# ATLAS TOWER

October 6, 2023

Chace Pedersen, Planner 1  
Kittitas County Community Development Services  
411 N. Ruby Street, Ste 2  
Ellensburg, WA 98926

As discussed on our phone call, we have moved the tower 25' to the west of its original location. As shown in the updated drawings the tower will still be 111' from the west property line. In the unlikely case of the tower falling over, it still would not land on any other property. The design is for a 100' tower which will still allow an additional 11' to the west property line.

SHEET TITLE:  
**SITE PLAN**

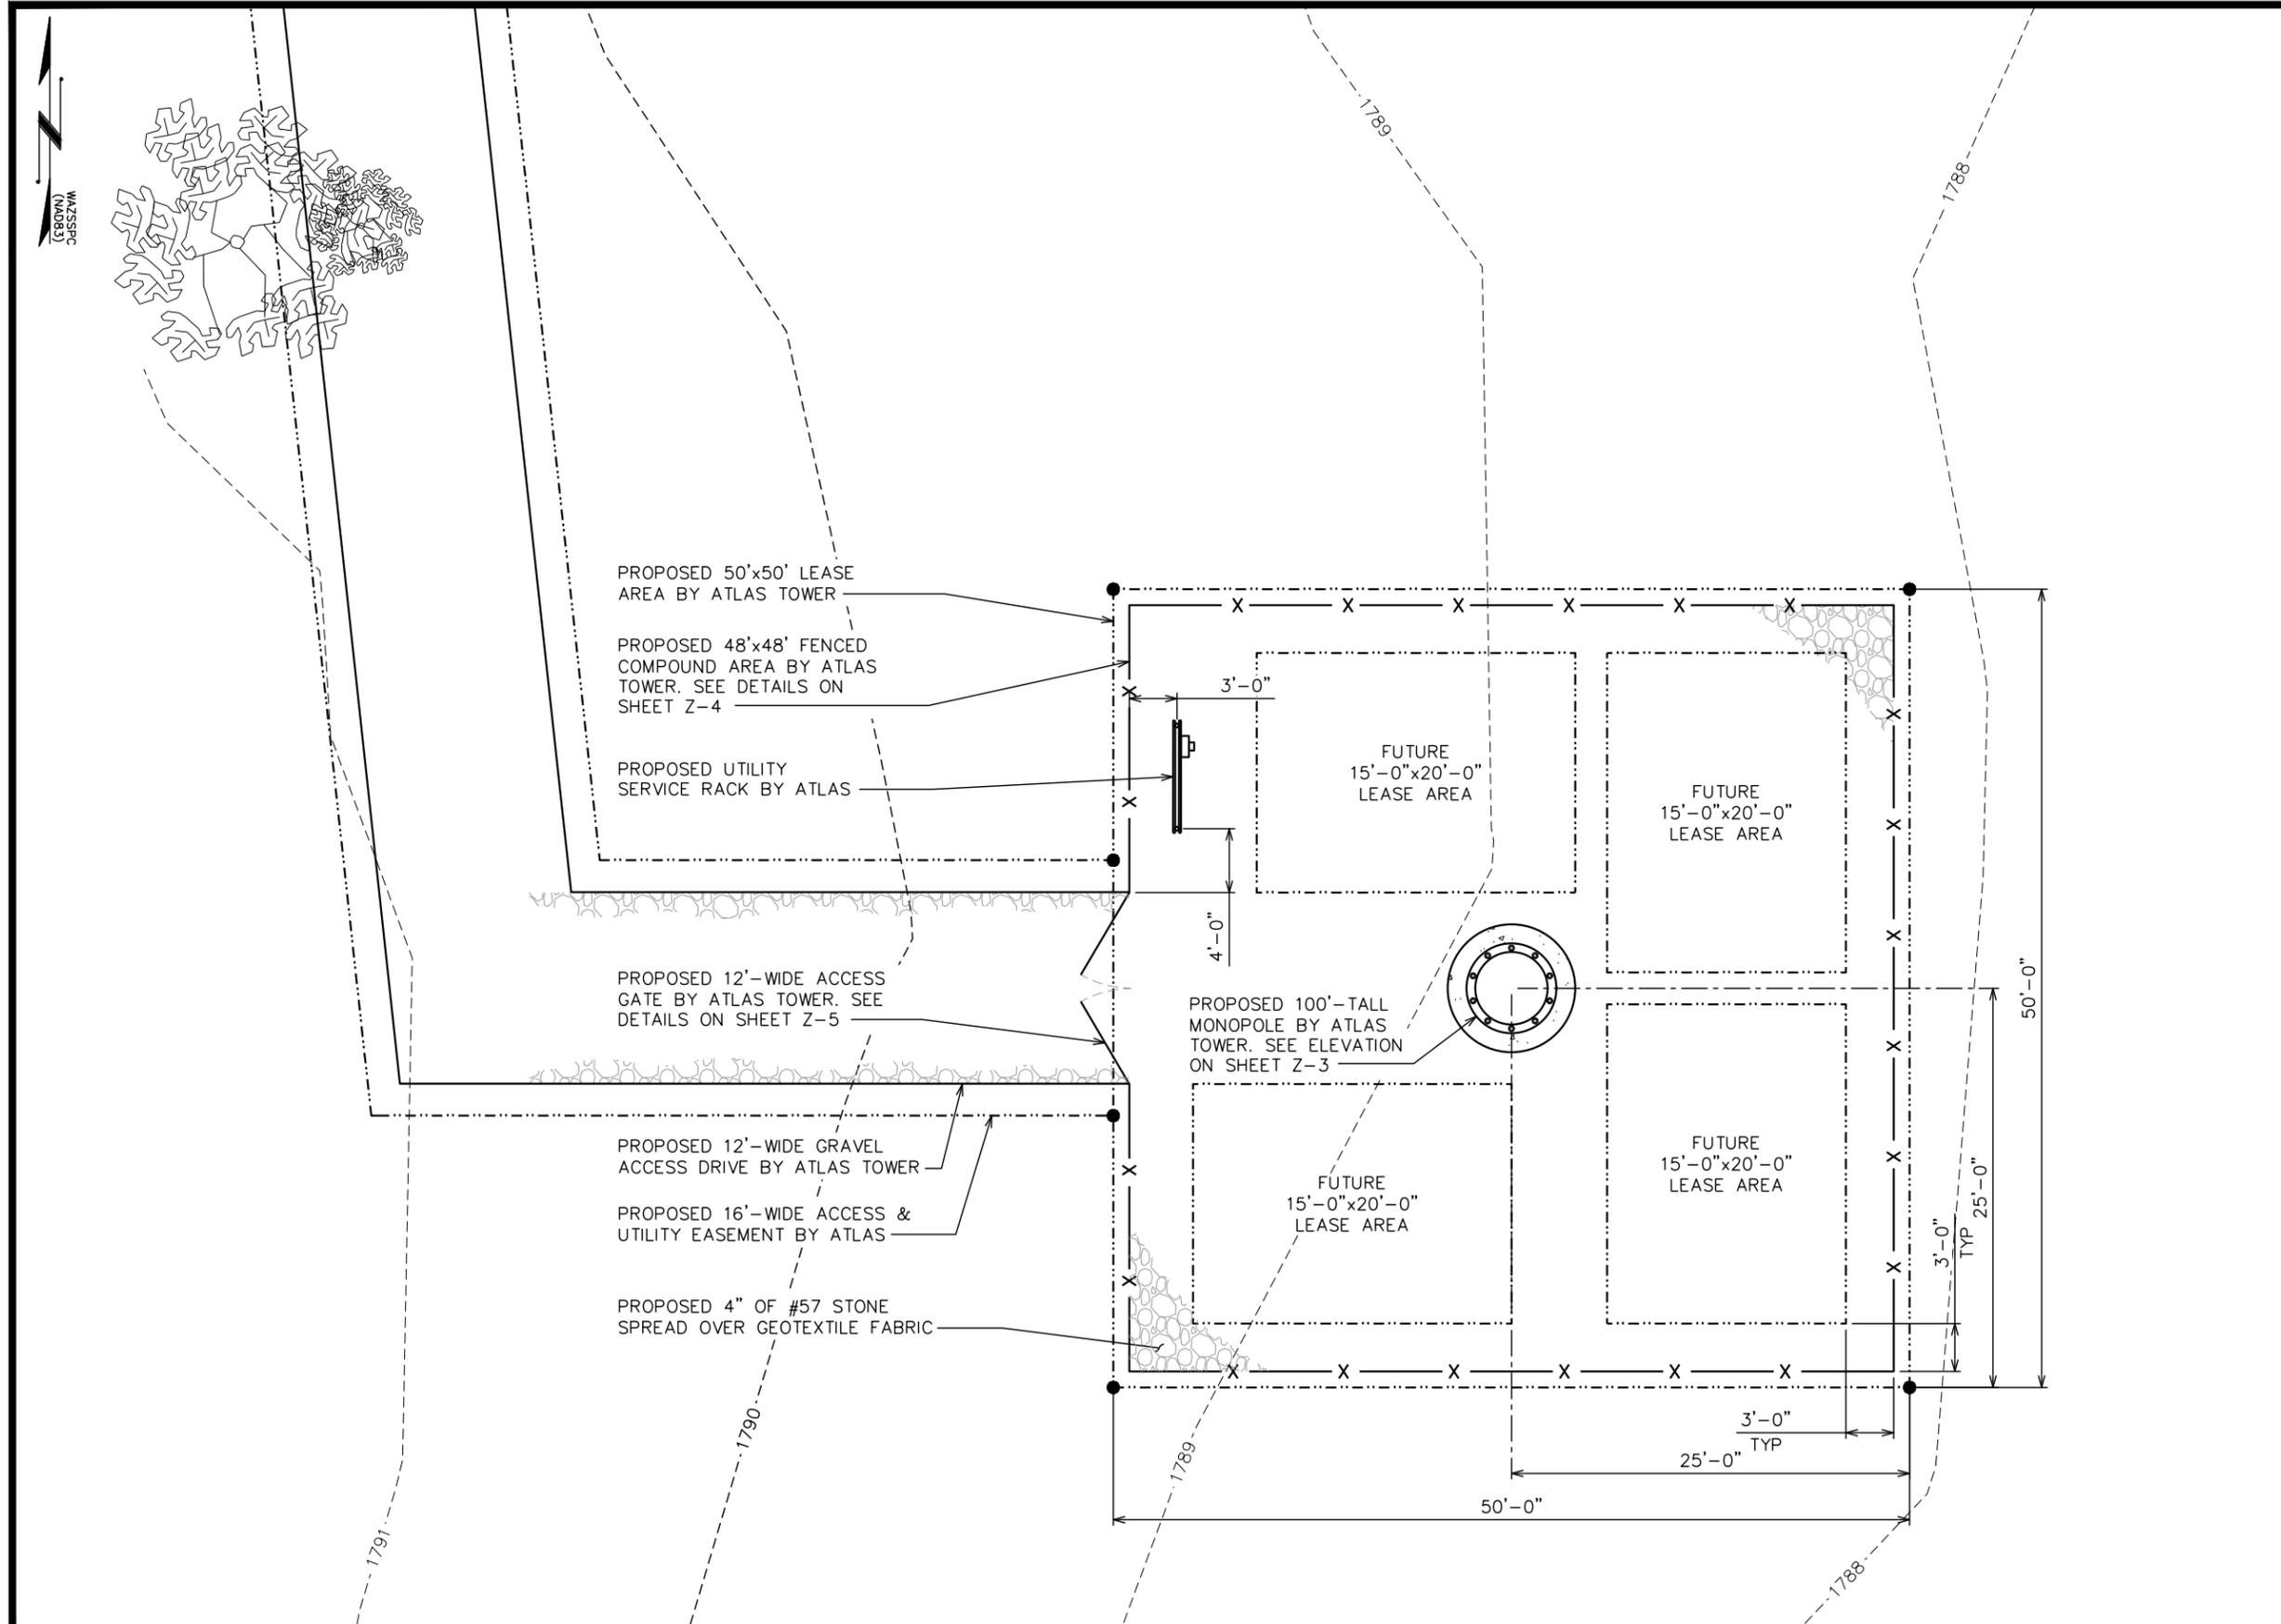
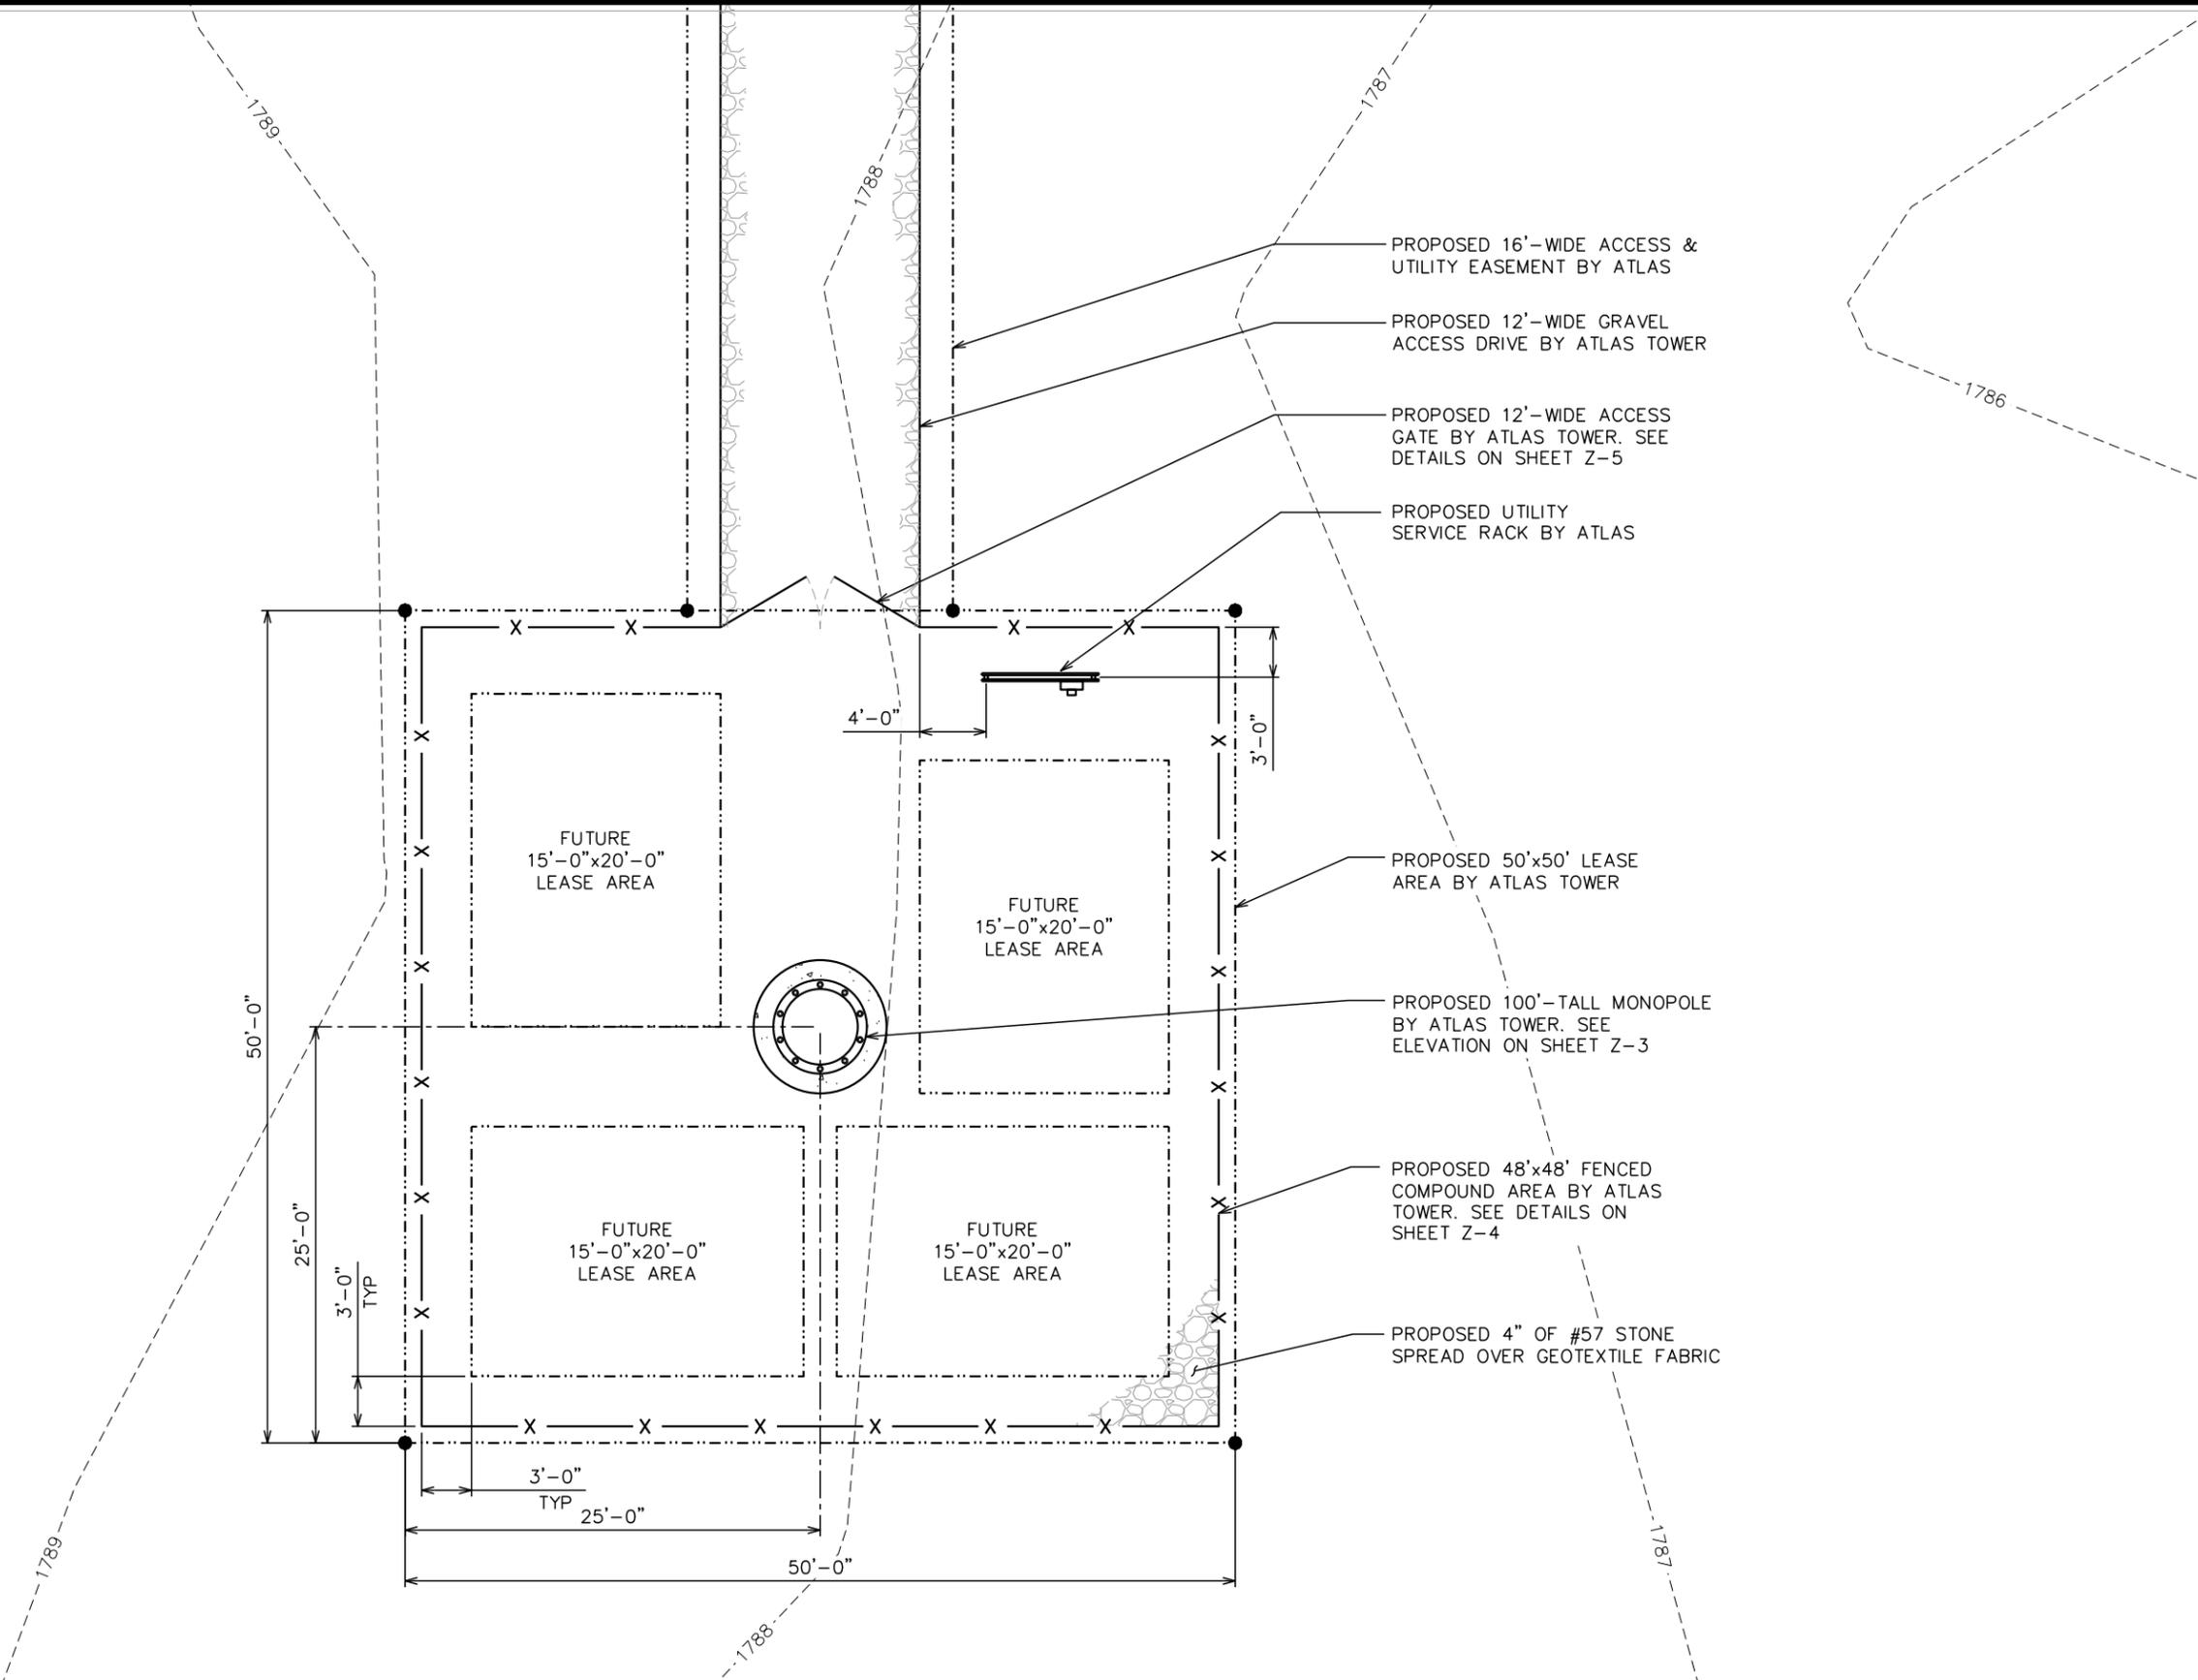
We are in the process of updating our survey to reflect this 25' shift to the west. The ZDs will be updated with the 1A information once we receive it. I will send the final updated ZDs to you once I receive them. However, I feel confident that the distance from the property line will still be over 100' from the property line.
